APPROVED
Limited building only review
Permit holder responsible for full compliance with the code

CORY WYAND (HOMEOWNER) - 20 BLAIRWOOD DRIVE

TITLE
16'X20' GARDEN SHED WITH GABLE PORCH

SIZE	DWG NO	REV
C	WYAND_SHED	A
SCALE: 0.040	UNIT WT: INCHES UNLESS NOTED	SHEET 2 OF 6

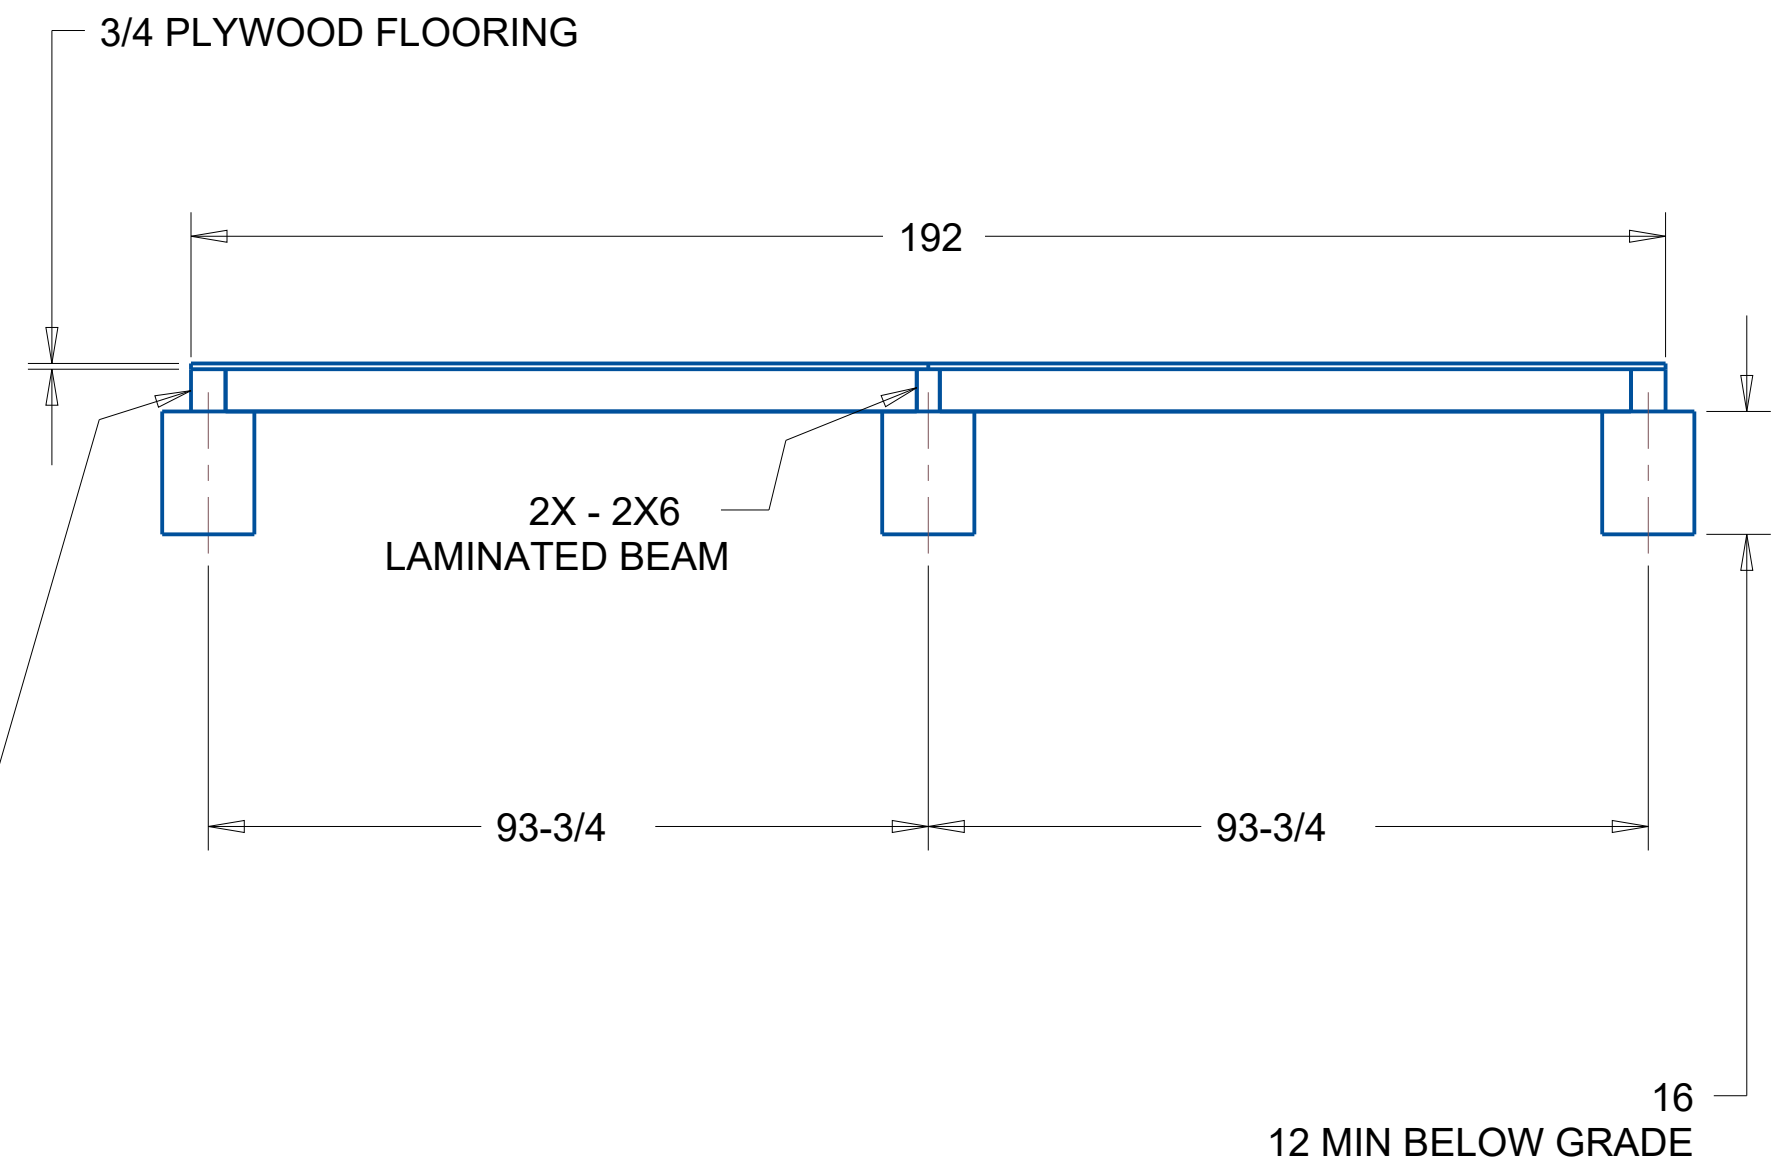
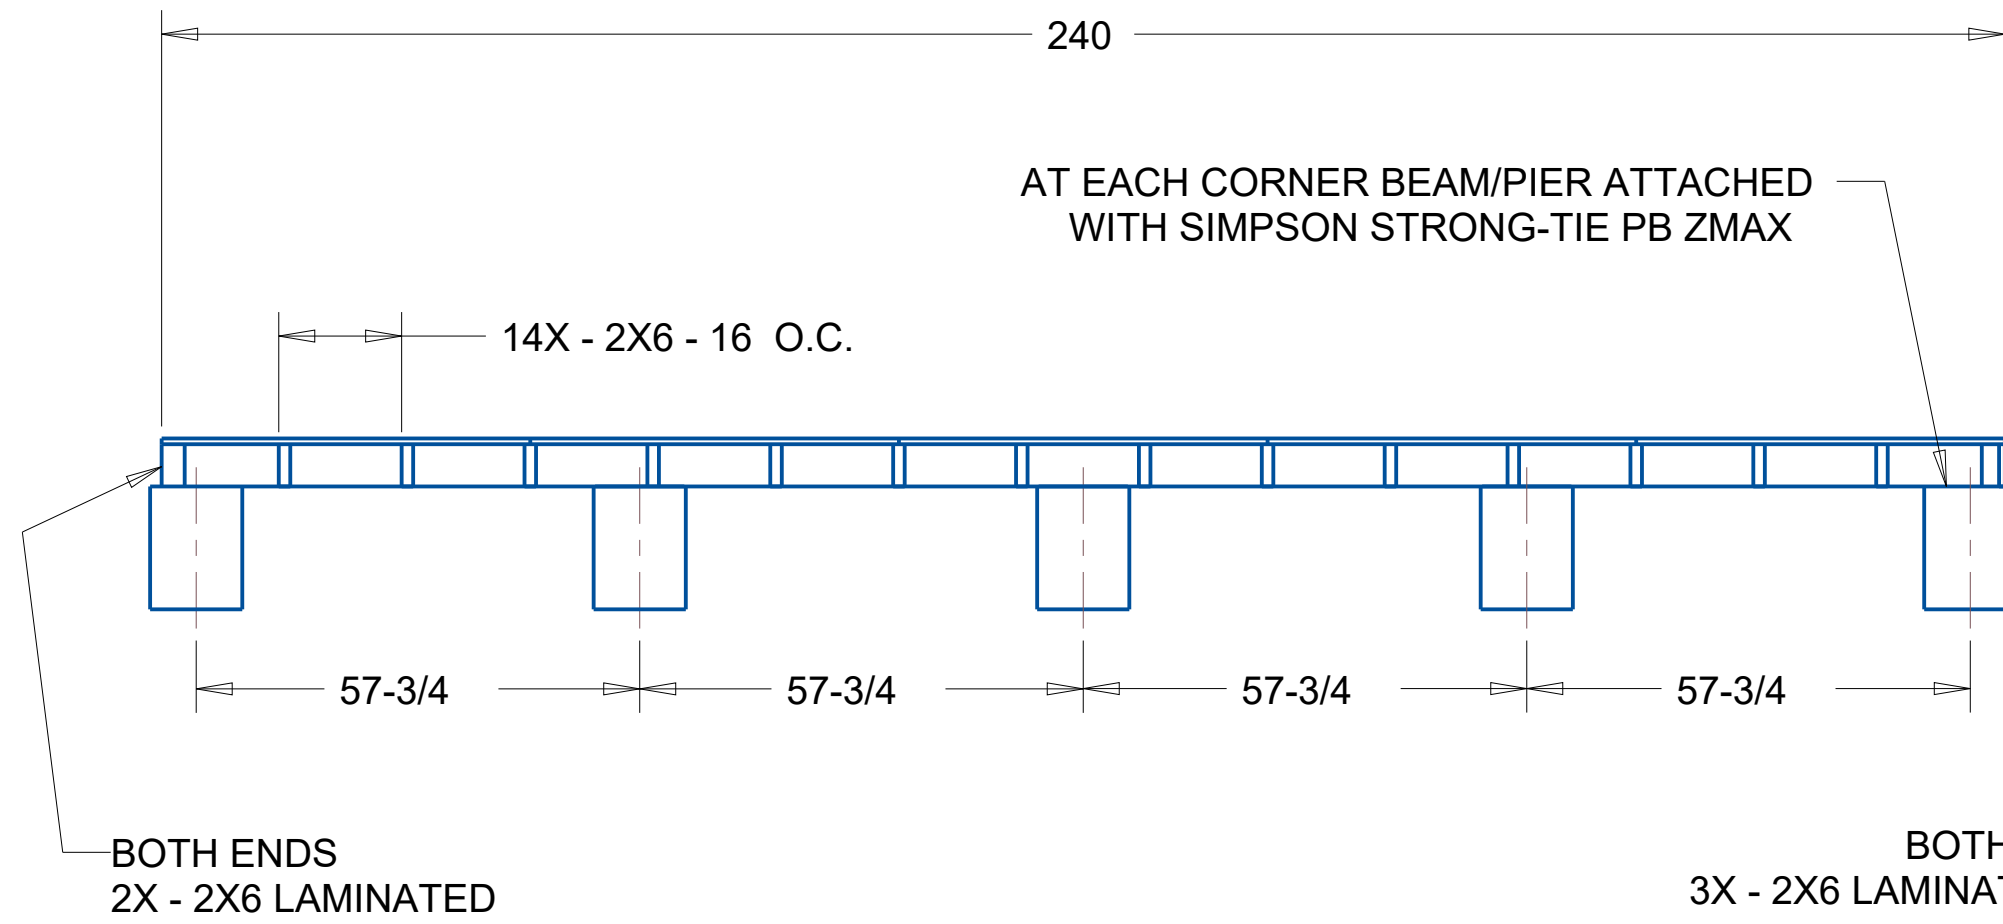
Bottom of footing shall be minimum 12 inches below grade
